Quality Audit Report

Athlone Link Road Phase 2 – Coosan Point to The Crescent

On behalf of **Westmeath County Council**

May 2025

Storm Drainage Network Drawing

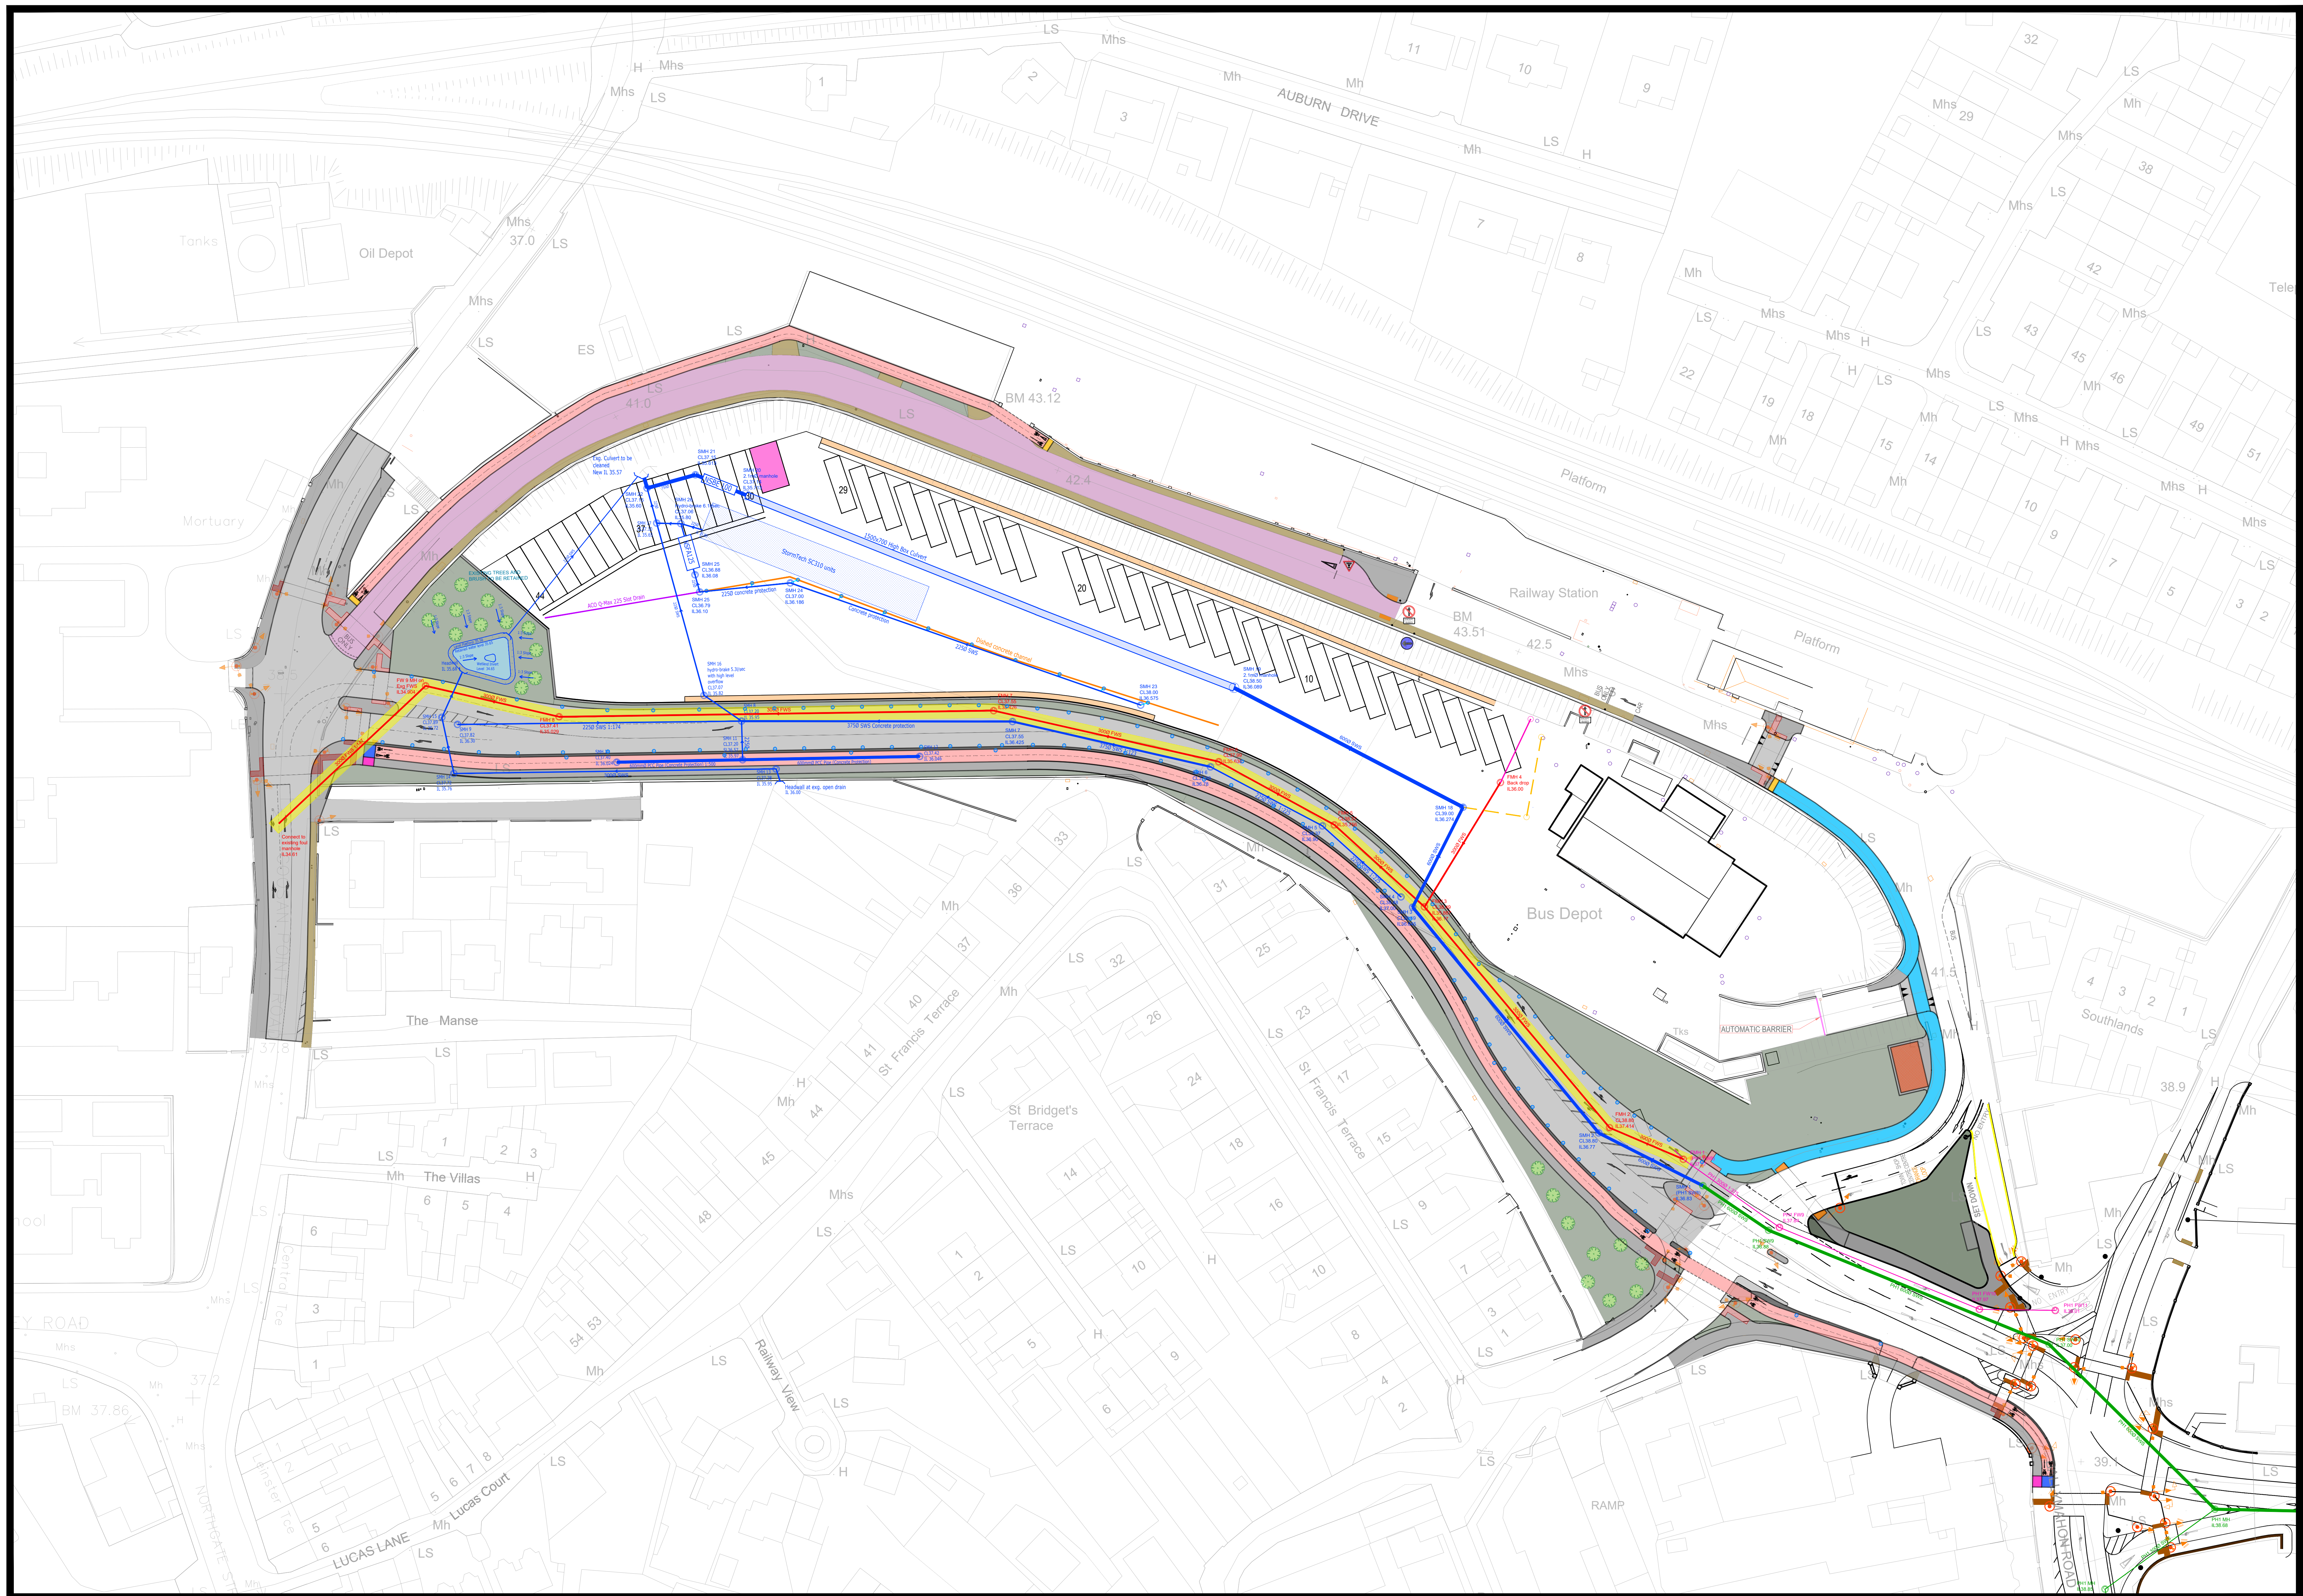
| Ref | Feature | Conforms | Access Comment | Action |
|-------|---|------------------------------------|--|---|
| 2.2.3 | Are all surface water gullies / slot drains outside of the desire line or less than 13mm wide and set at right angles to the line of traffic? | Yes. New Link Road | It appears the proposed gulleys along the new link road are located clear of pedestrian crossing points. Contours are not provided, but it appears that gulleys have also been positioned slightly upstream of pedestrian crossing points, which is considered to be good practice. | To be taken into account at detailed design. Detailed design should re-check location of gulleys in conjunction with a contour plan. |
| | | Unknown. Southern Station Road. | Existing and proposed gulleys are not indicated on the existing Southern Station Road. | Gulleys should be positioned clear of pedestrian crossing points, and preferably upstream. Potentially existing gulleys may need to be relocated. |

| Ref | Feature | Conforms | Access Comment | Action |
|---|---|---------------|--|---|
| 2.4.4 | Is the crossing free of road gullies, gratings or channels that may cause wheelchair or stick users problems? | Unknown | It appears the proposed gulleys along the new link road are located clear of pedestrian crossing points. Contours are not provided, but it appears that gulleys have also been positioned slightly upstream of pedestrian crossing points, which is considered to be good practice. | To be taken into account at detailed design. Detailed design should re-check location of gulleys in conjunction with a contour plan. |

Grid 4-Cycle/Footpath-P3

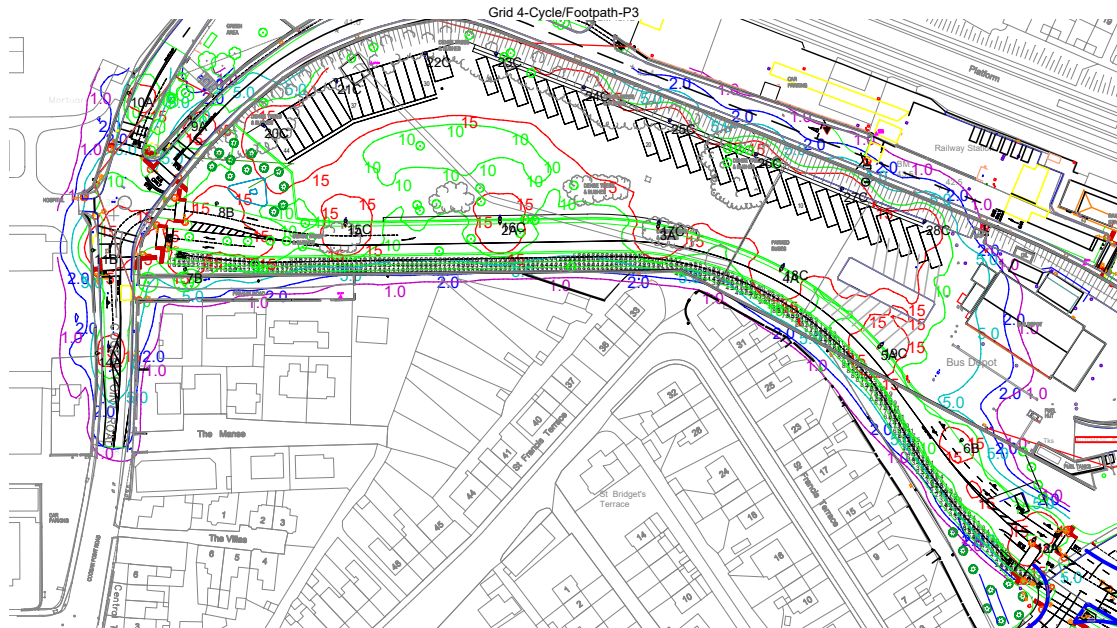
| Ref | Feature | Conforms | Access Comment | Action |
|--------|--|-----------|---|--|
| | | | <p>It is noted that the proposed new link road will be lit. The footpath is remote from the carriageway. Therefore, it is not obvious that the footpath will be adequately lit, just relying on “spillage” from the carriageway illumination.</p> <p>No details are provided for lighting within the exiting Southern Station Road.</p> | <p>The proposed, the road lighting will need a design check to ensure the scheme complies with design standards, including for the footpath.</p> <p>To be taken into account at detailed design. The adequacy of the existing street lighting should be considered.</p> |
